Your Ref: OWPC15269
Our Ref: AL/83/17/PL 17-07-2017
Please ask for:
Michael Eastham

Demolition of existing dwelling & erection of 1 No. dwelling.
Mildmay Hook Lane Aldingbourne

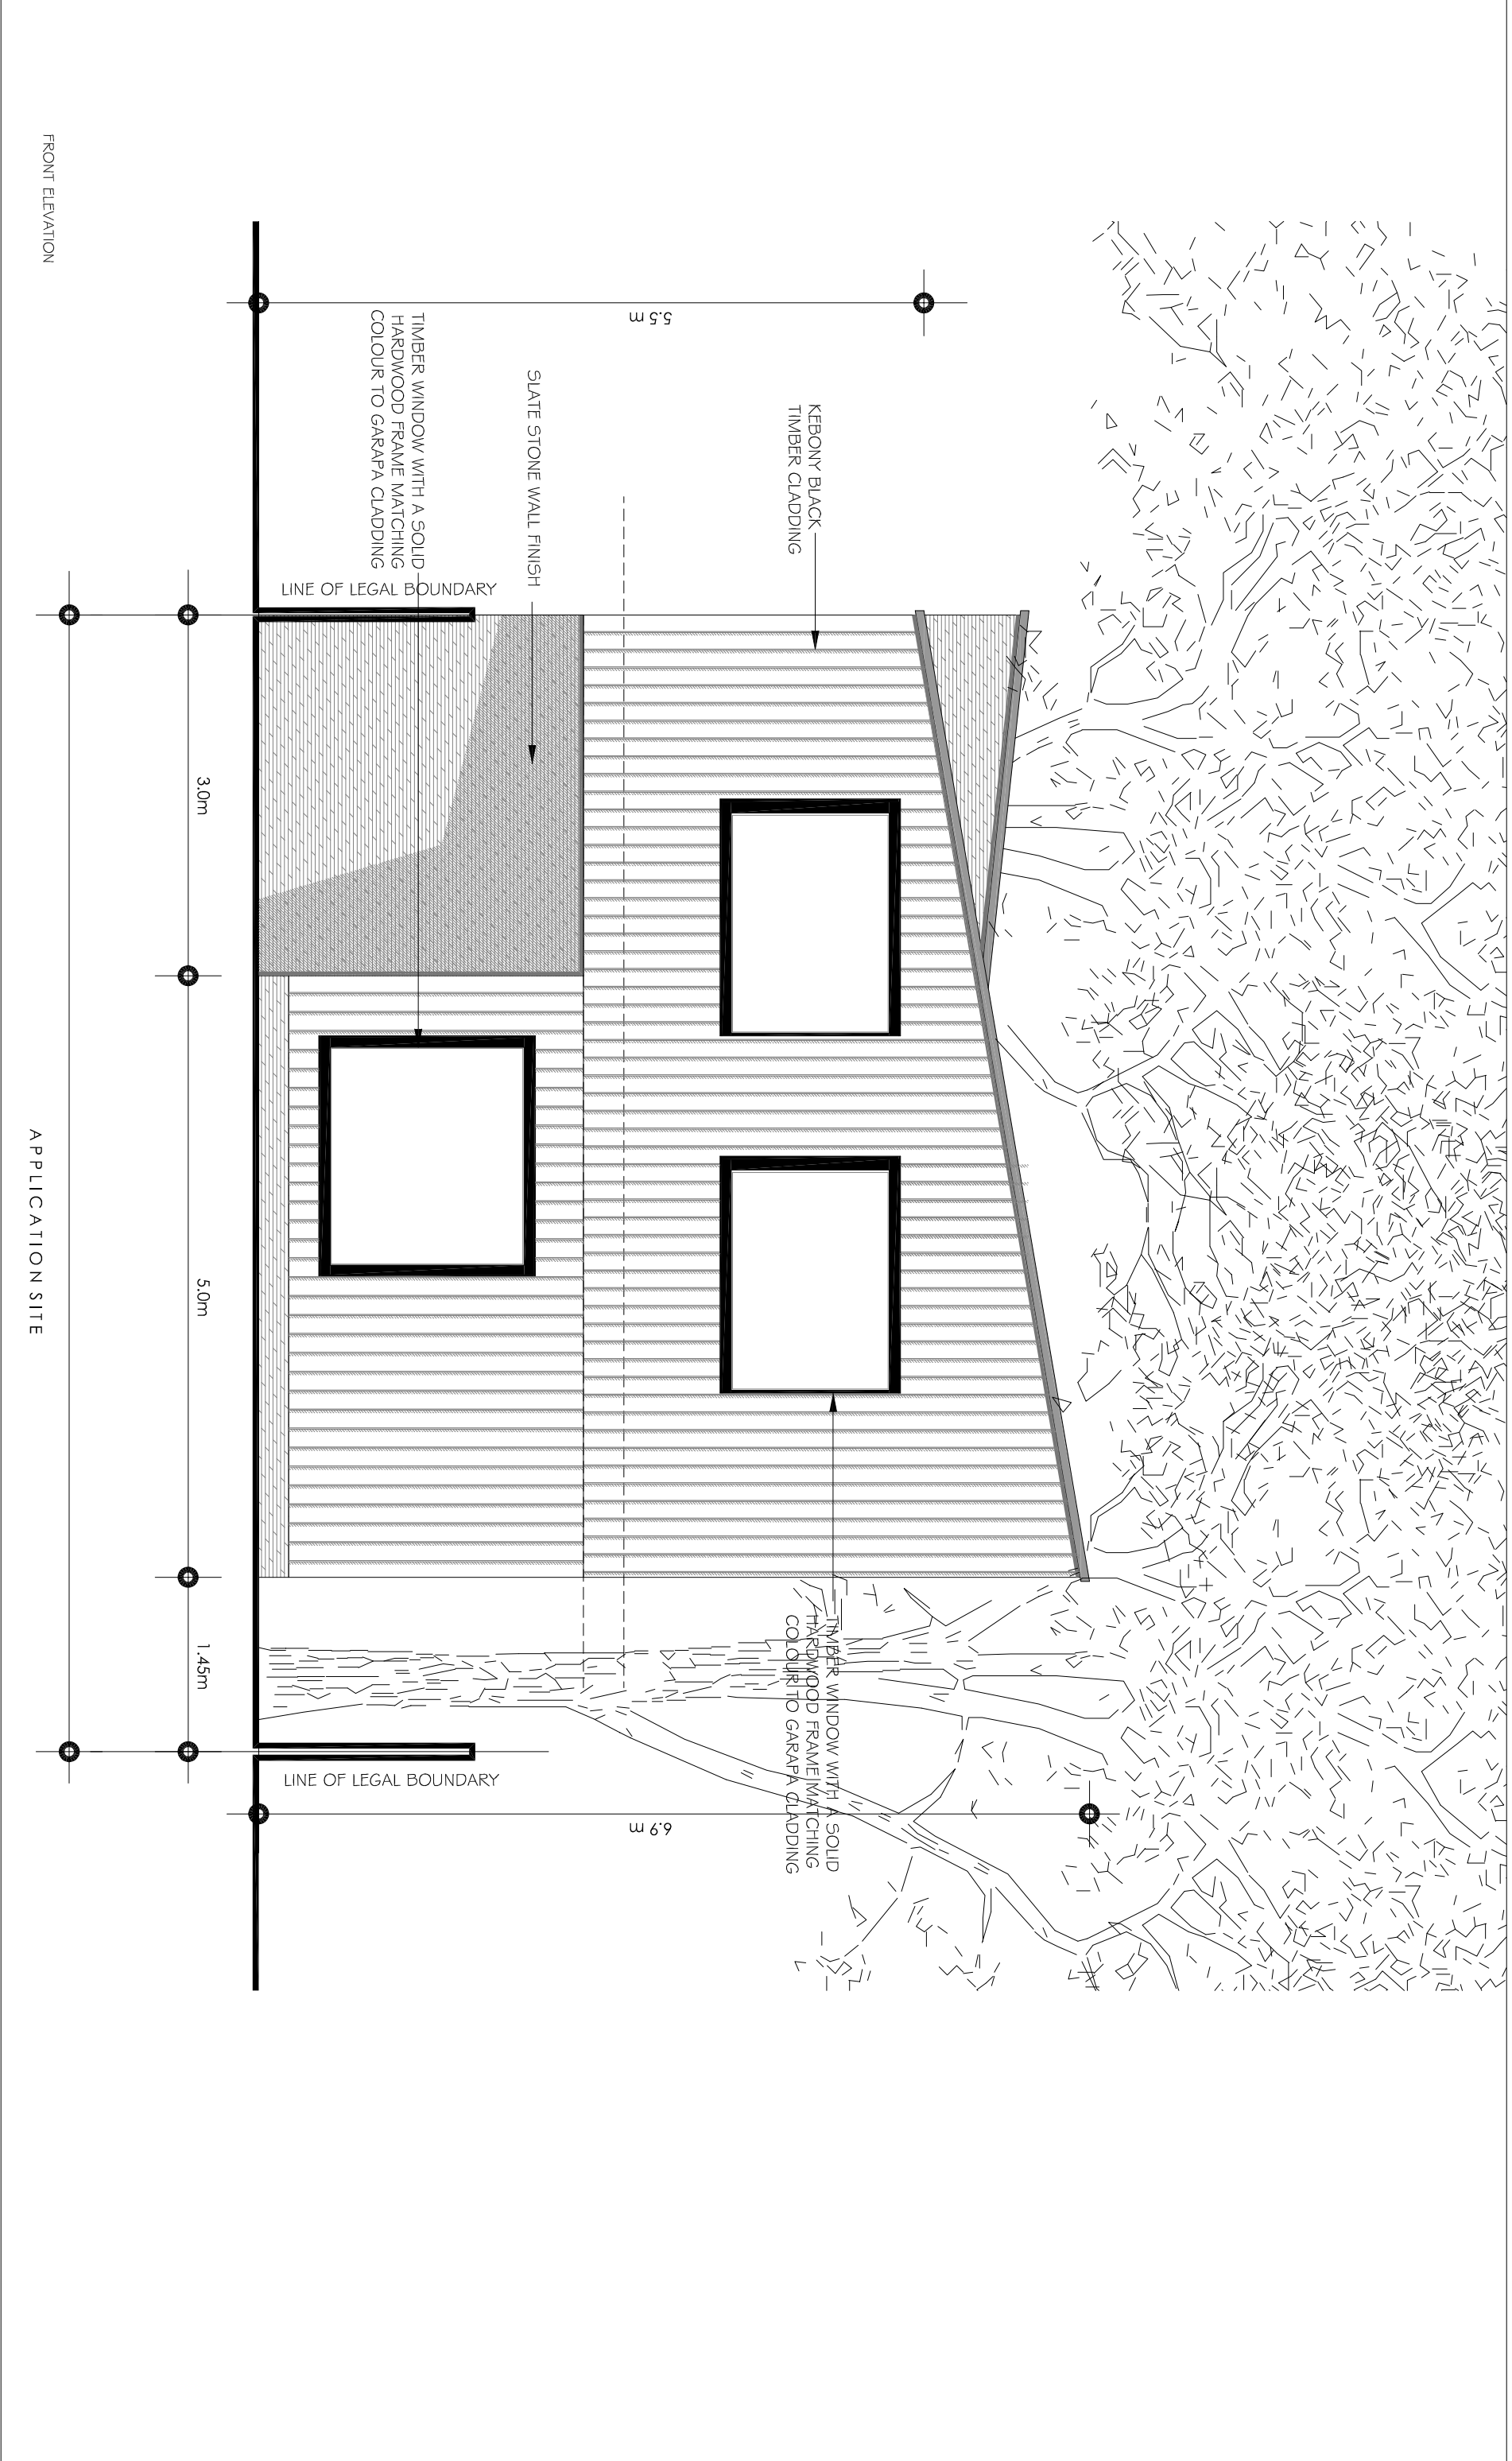
In the street scene view plan the design of the house is very overbearing and the proposed design and materials are out of character for the local area.

PROPOSED REAR ELEVATION

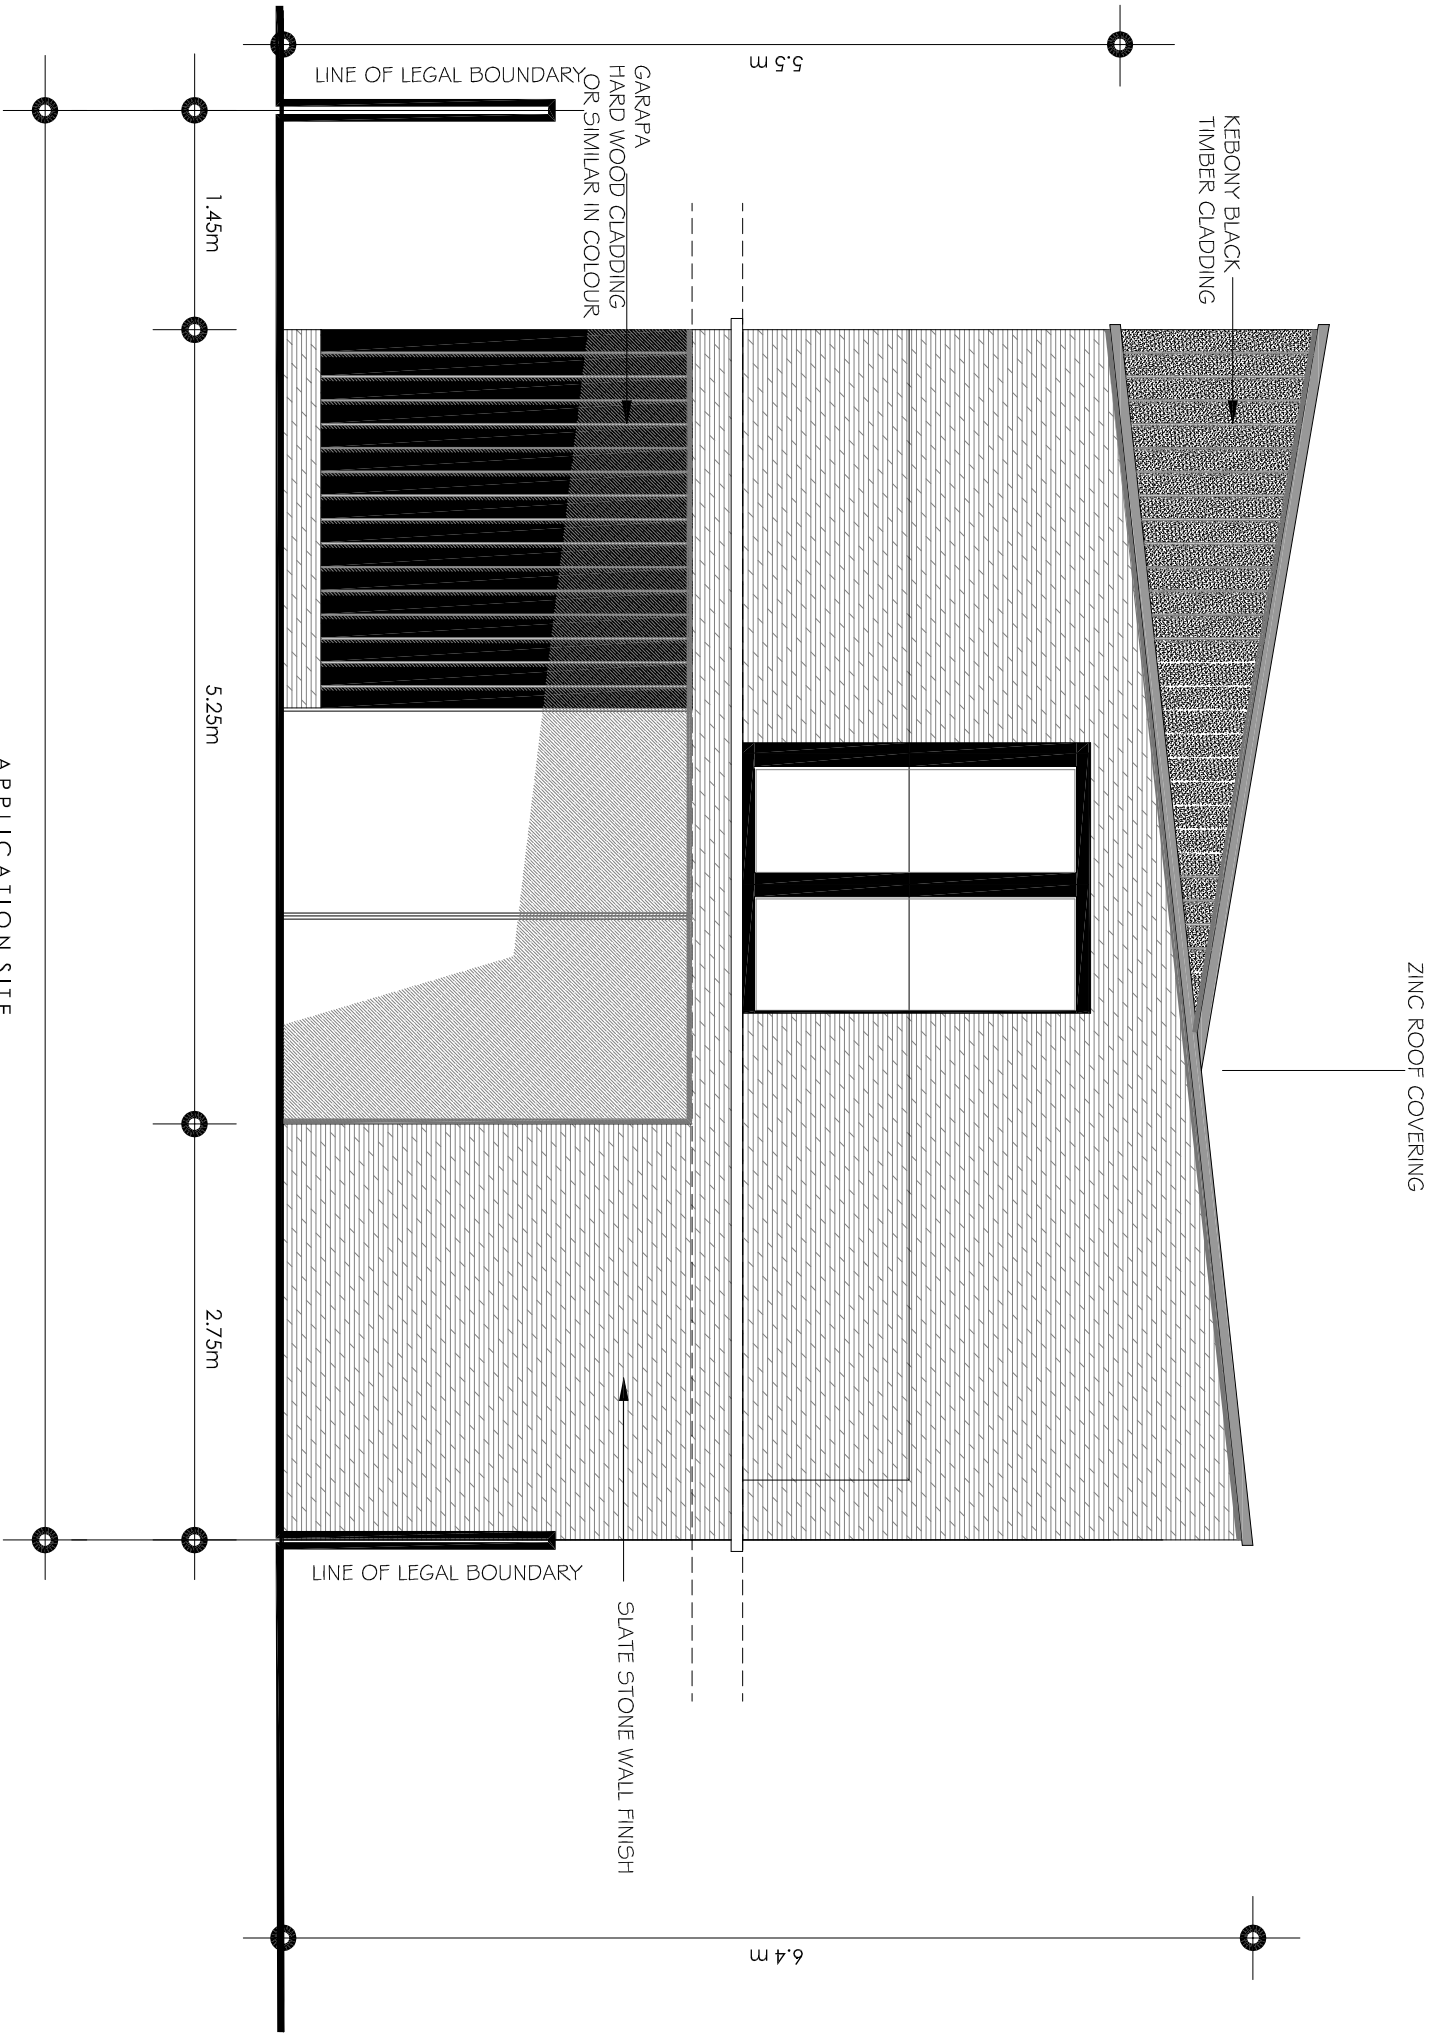
I am particularly worried as this plan has a set of patio doors from the master bedroom that appears to be at an angle looking straight into our back garden. There also appears to be a balcony area. Anybody sitting/standing in that area would have a direct view in our garden and would make me and my feel uncomfortable to sit out and enjoy our garden. We bought this property 3years ago specifically for the privacy it gave us with no windows/doors overlooking our back garden at all.
